PLANNING CONSULTATION RESPONSE

Application No	2026/0428
Proposal	Erection of a single storey Portakabin modular building providing nursery facilities.
Address	Brierley Church Of England Primary School, Beech Close, Brierley, Barnsley, S72 9EJ
Date of Consultation Reply	06.07.2026
Consultee	Charlie Atkinson Design & Conservation Assistant

This application seeks planning permission for the erection of a single storey Portakabin modular building to provide nursery facilities at Brierley Church of England Primary School.

**3** Rear Elevation  
1 : 100

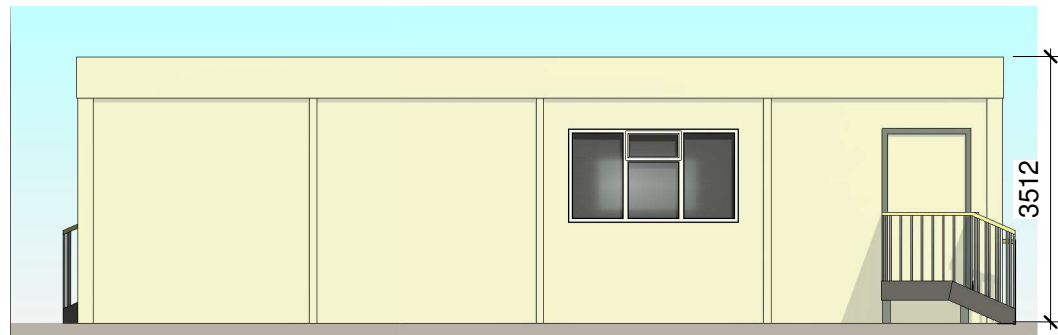
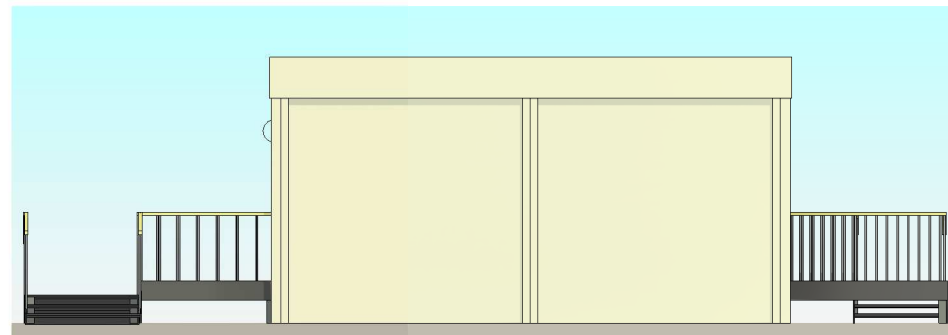
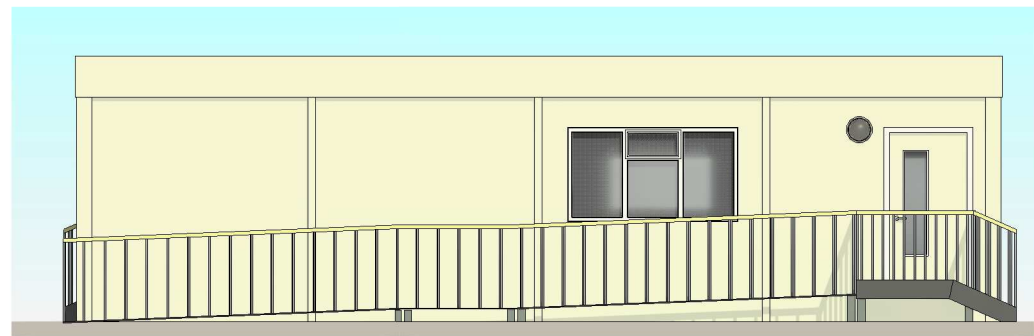
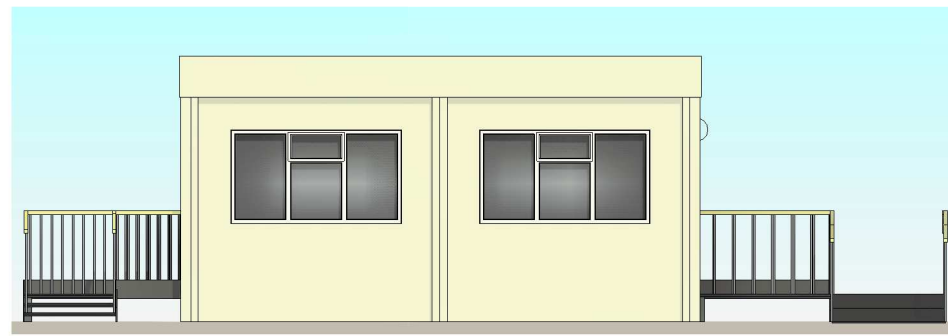
The elevational design of the proposal is contrary to Policy D1 of the Barnsley Local Plan (2019) 'High Quality Design and Placemaking'. The elevational design of the proposal fails to appropriately respond to or positively contribute to the surrounding character of the area, including the school buildings and the adjacent residential properties.

However, the external design of the portacabin as proposed, with an external plastisol coating, a colour of honesty yellow, poorly proportioned windows, and windows that are 'flat' to the external walls, would visually be a crude addition to this setting.

I have seen other examples of portacabins with more sensitive external cladding, in a more contextually sensitive colour, with better proportioned windows, and windows with a greater depth of reveal, which would help to fit this structure better into the existing setting of the school and residences.
